## Grounds for Objection

### 1. Design Inconsistency

title:
Proposed Floor Plans

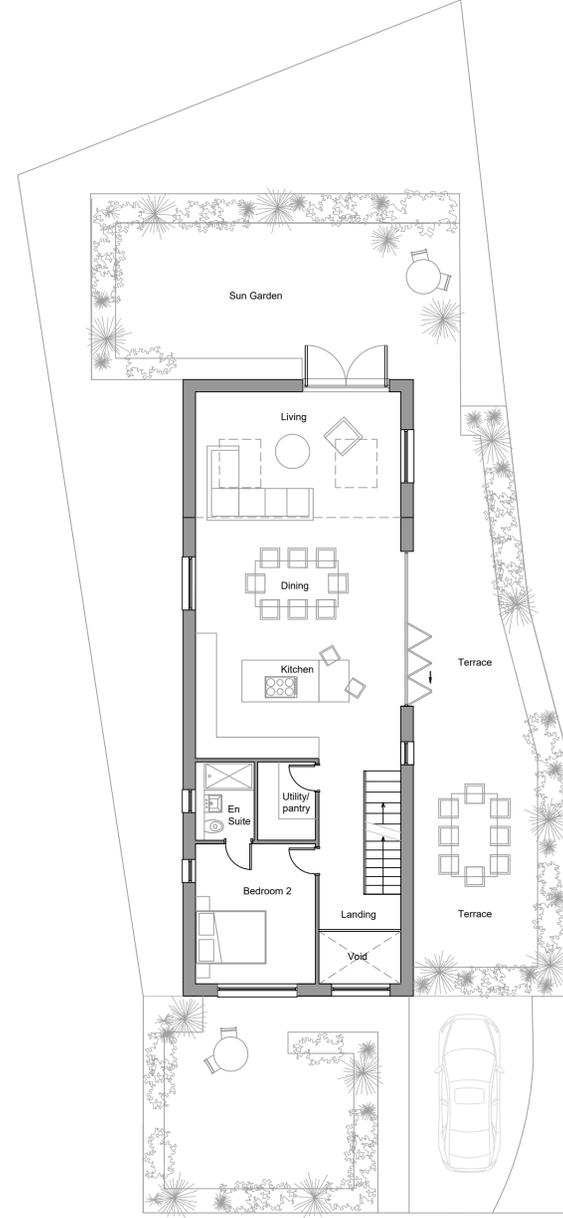
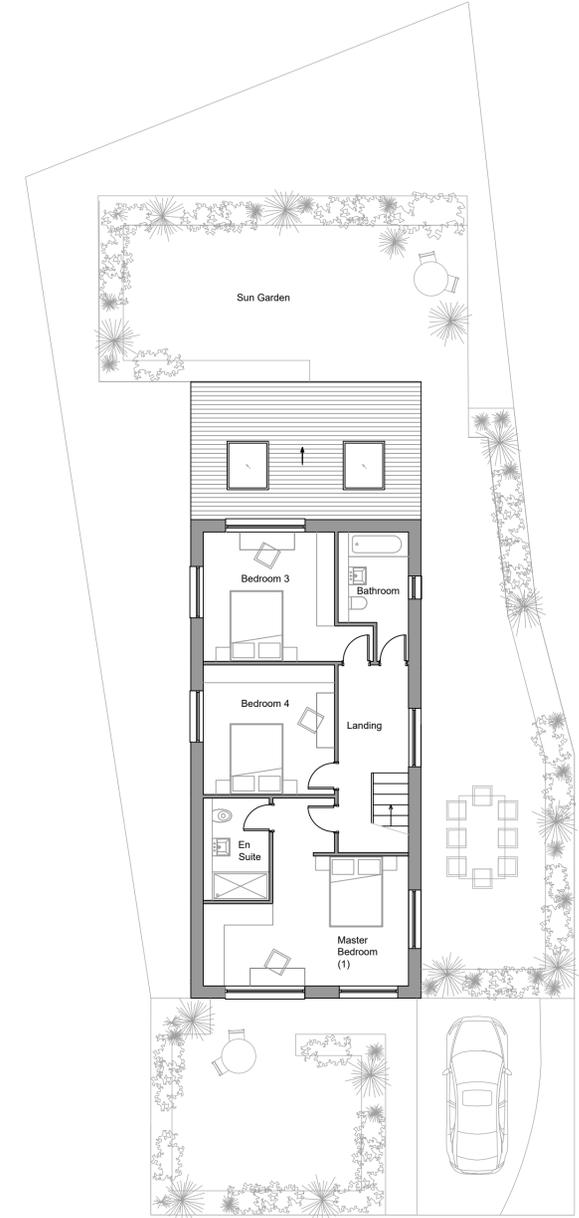
The second-floor en-suite door is shown opening **inward**, while the first-floor en-suite door opens **outward**. This inconsistency suggests a lack of coordinated design logic and undermines the credibility of the submitted plans.

Inward-opening doors can pose a safety risk in medical emergencies, while outward-opening doors may obstruct adjacent circulation space. The inconsistency raises questions about whether either configuration meets regulatory standards.

The presence of contradictory internal layouts within the same dwelling suggests the plans have not been fully reconciled. This undermines the reliability of the application and may mislead consultees and officers assessing usability and compliance.

- Require the applicant to submit **corrected and reconciled internal layout plans**, ensuring consistency and regulatory compliance
- Reassess the usability and safety of the proposed en-suite configurations in light of Building Regulations
- Confirm that internal layout drawings will be subject to appropriate scrutiny to prevent misleading or contradictory submissions
